Our ref: SO/2023/123043/03-L01
Your ref: EN070007 – Deadline 3
Date: 23 May 2023

APPLICATION BY LIVERPOOL BAY CCS LIMITED FOR AN ORDER GRANTING DEVELOPMENT CONSENT FOR THE HYNET CARBON DIOXIDE PIPELINE SCHEME

ENVIRONMENT AGENCY DEADLINE 3 (23RD MAY 2023) SUBMISSION:

NATIONALLY SIGNIFICANT INFRASTRUCTURE PROJECT – HYNET CARBON DIOXIDE PIPELINE

DRAWING TITLE  
**Ince - Above Ground Installation (AGI) Drainage Layout**

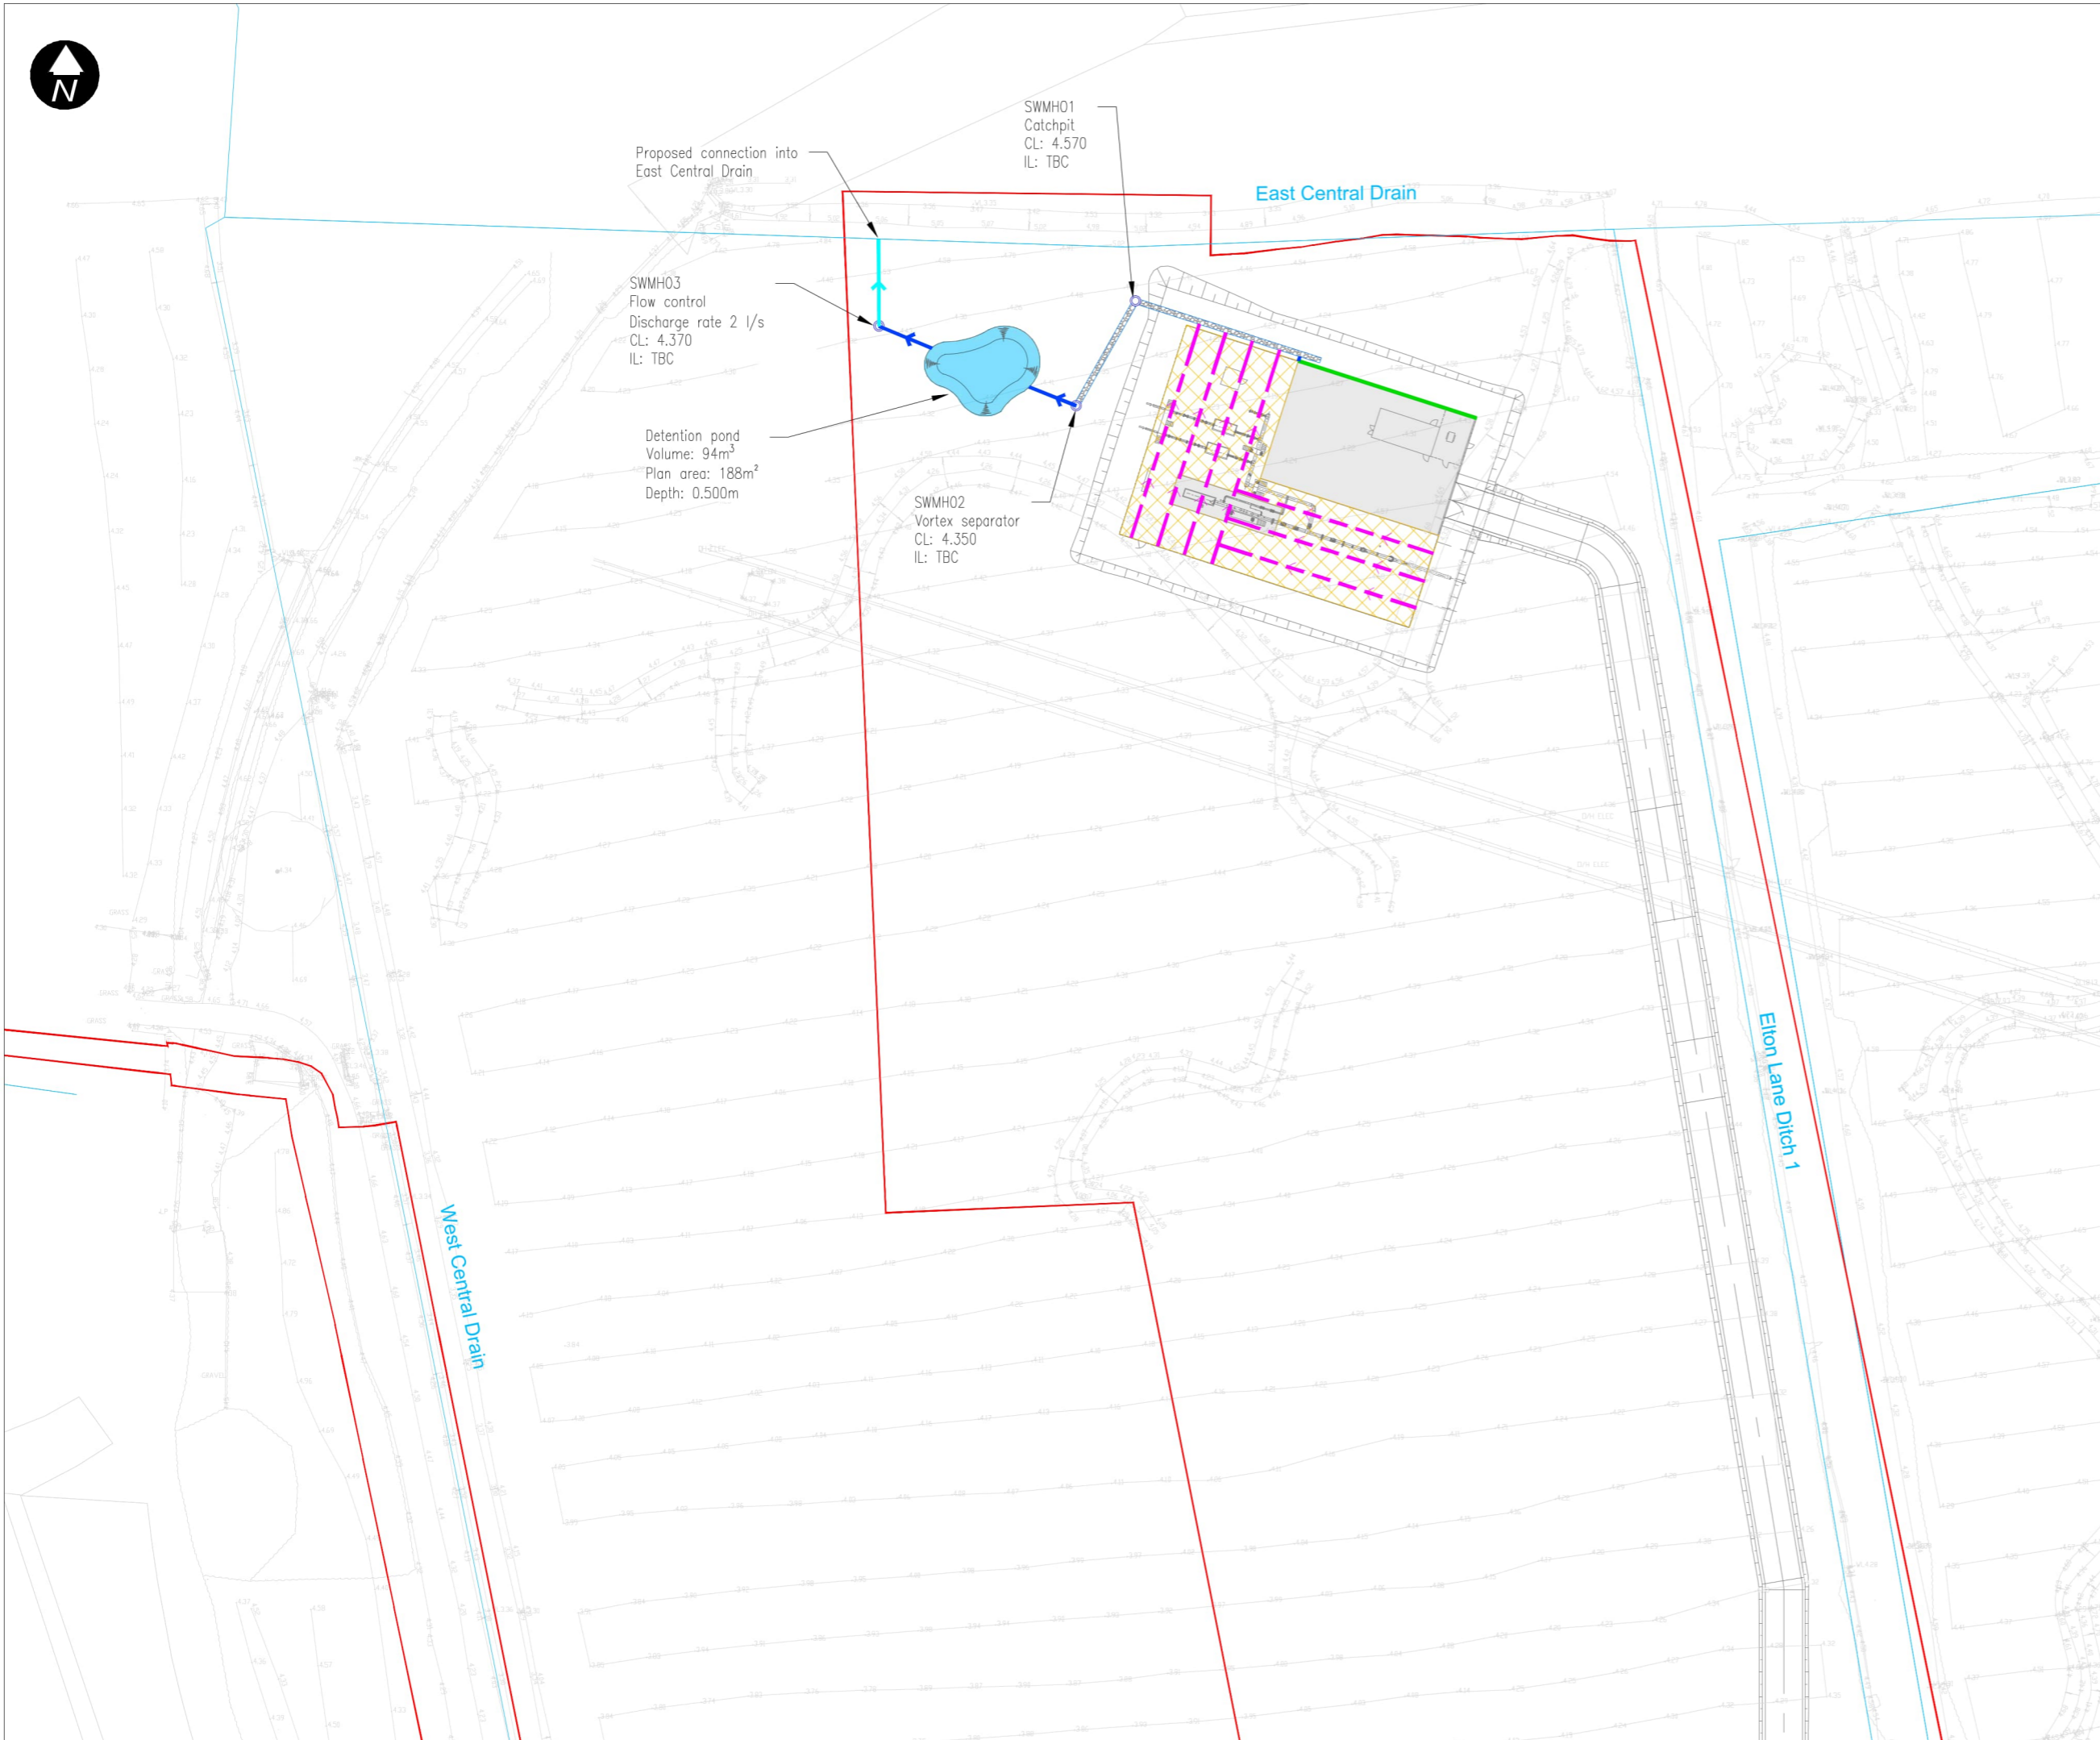
We welcome the applicant's comments [REP2-041] with regards to the Ince Pumping Station as in ref. 2.4.23 in Table 3.4. We acknowledge the principal flood protection measure, included in the Flood Risk Assessment (FRA), for the Ince AGI is to raise the

slab level sufficiently to prevent the ingress of floodwater into the installation which is considered acceptable. Our comments within our Written Representation [REP1-062] with regards to the land drainage function of the Ince Pumping Station was made to ensure that its limited capacity in dealing with residual flow rates only is noted and recognised in the FRA.

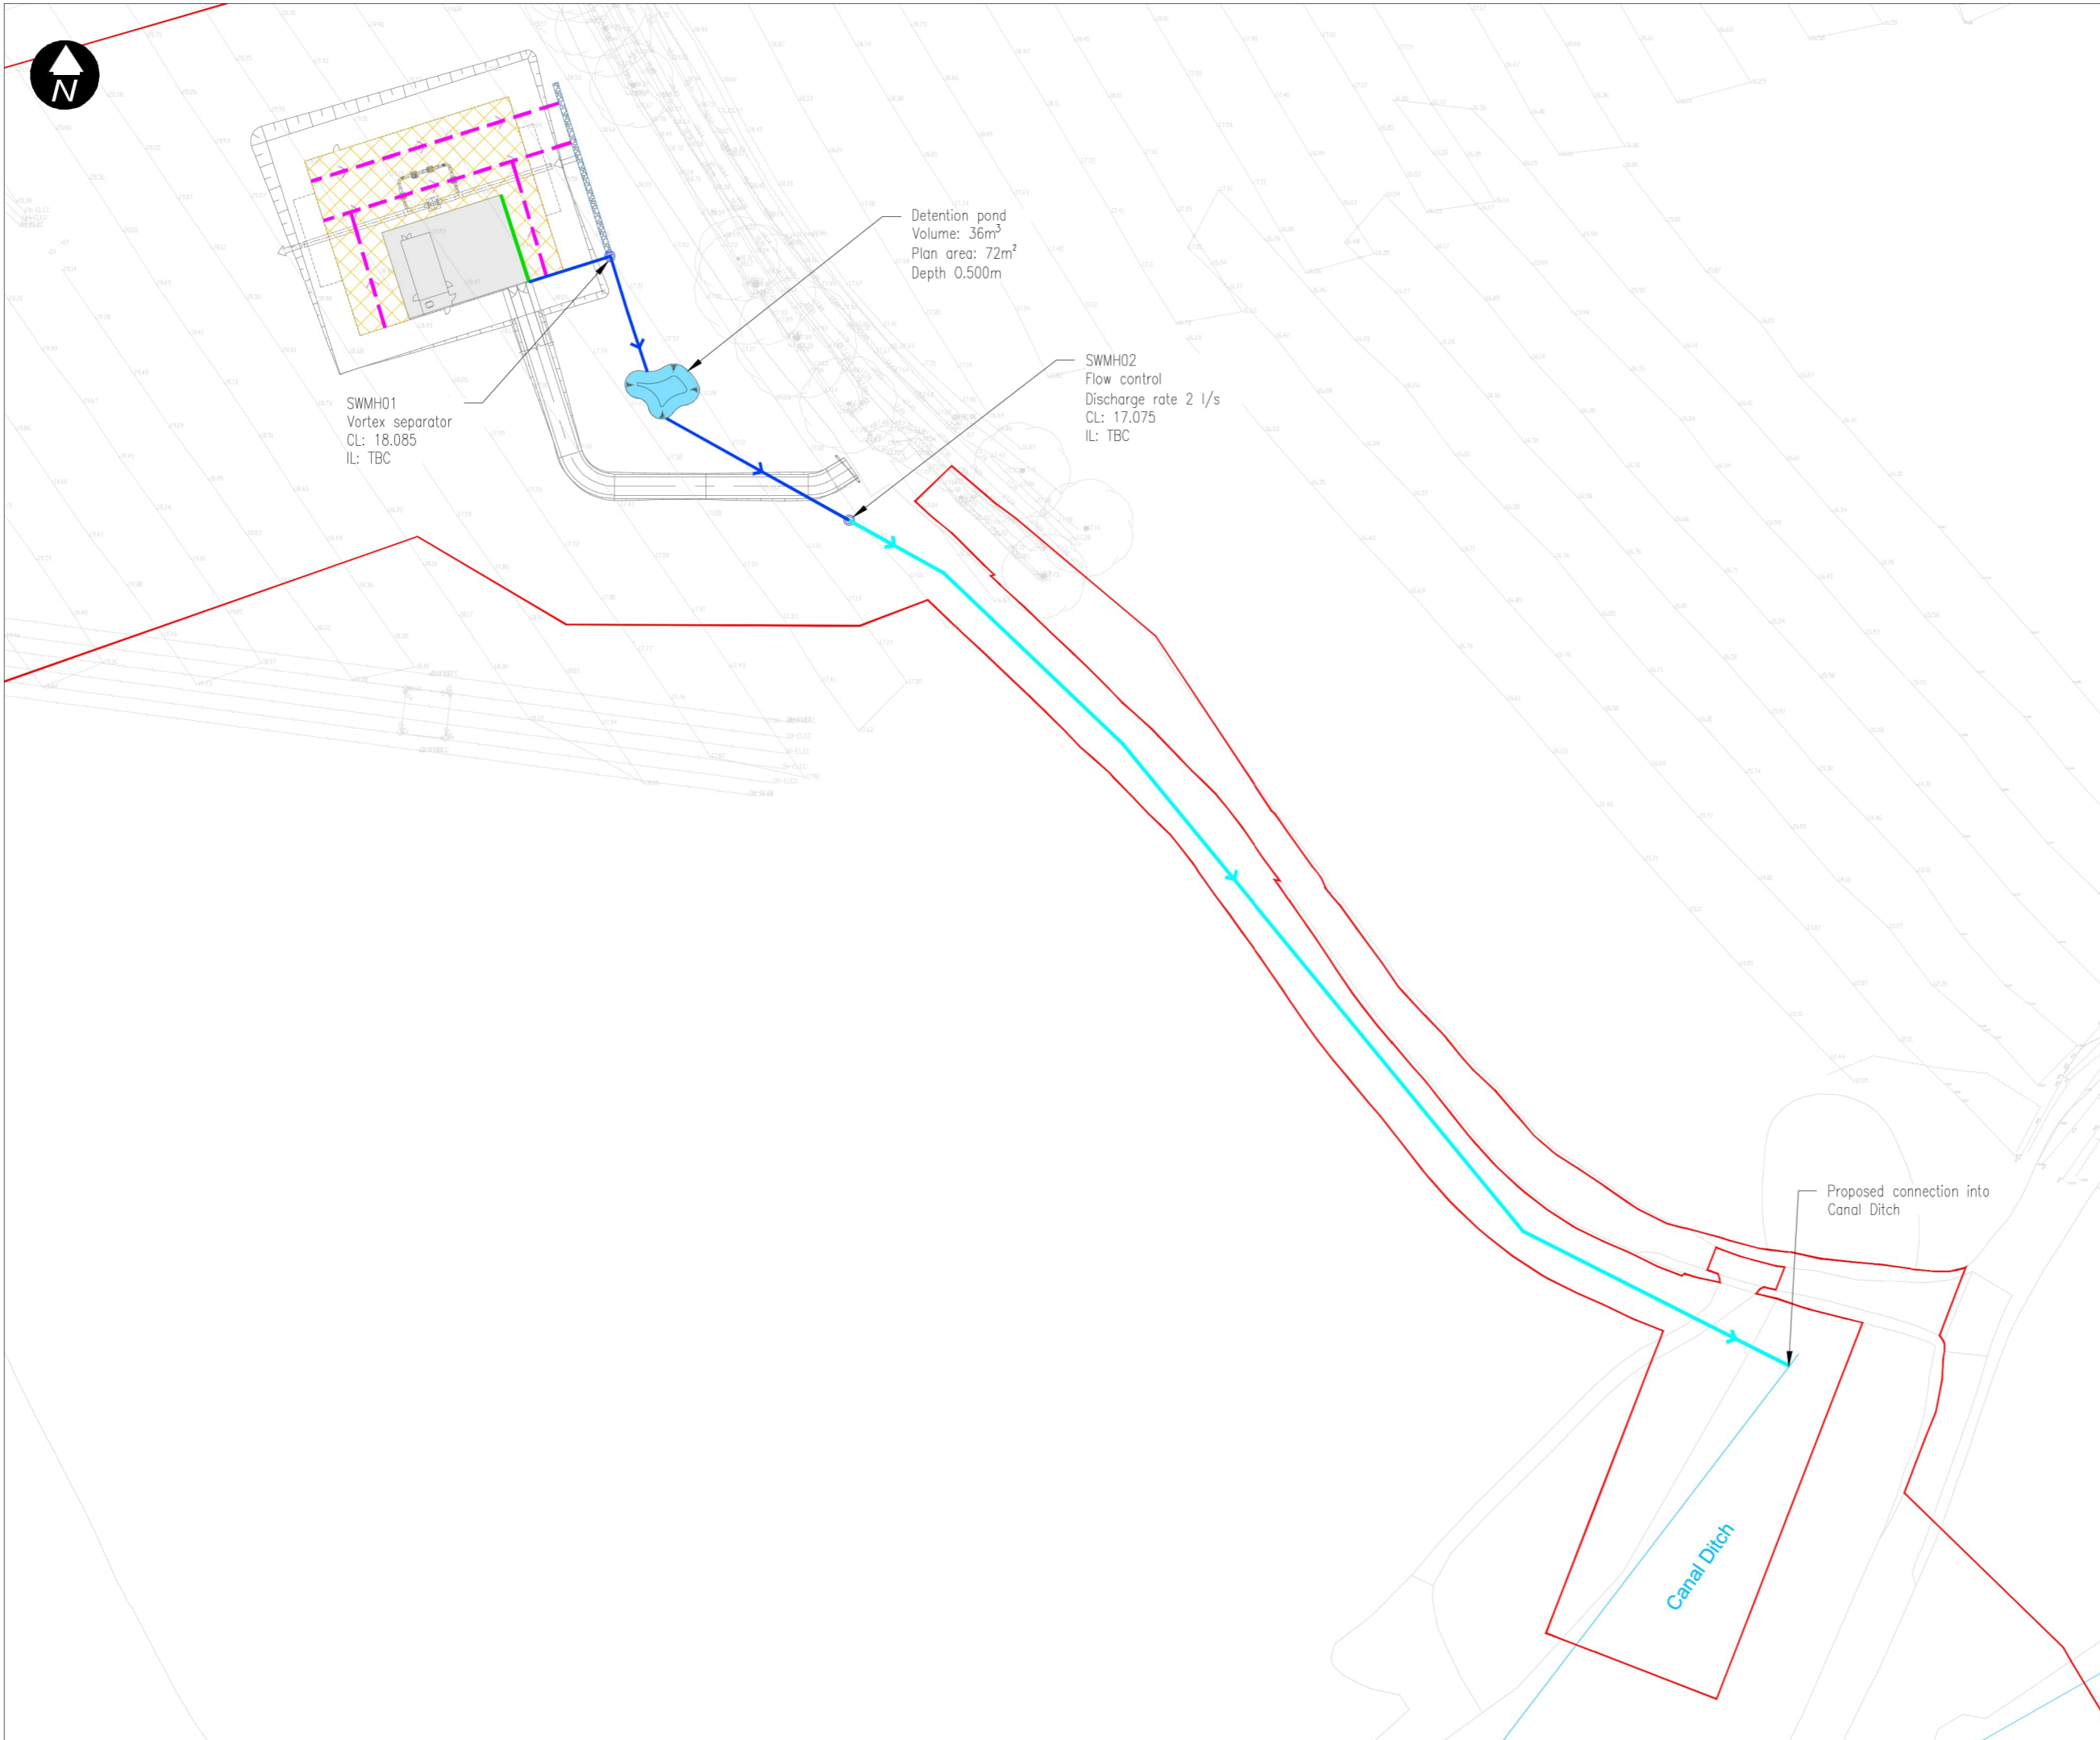
We acknowledge the applicant is involved in ongoing discussions with Essar Oil UK, where the surface water drainage connection for the Stanlow AGI to the wider existing Stanlow Manufacturing Complex effluent network has been identified as a discussion point [REP1-032]. We would advise the applicant to make the operator aware that such connections may necessitate changes to the operator's existing permits for the site. We acknowledge further clarification on the surface water drainage proposals and connection to the existing effluent network will be provided at the detailed design and would welcome engagement from the applicant and operator at this stage.
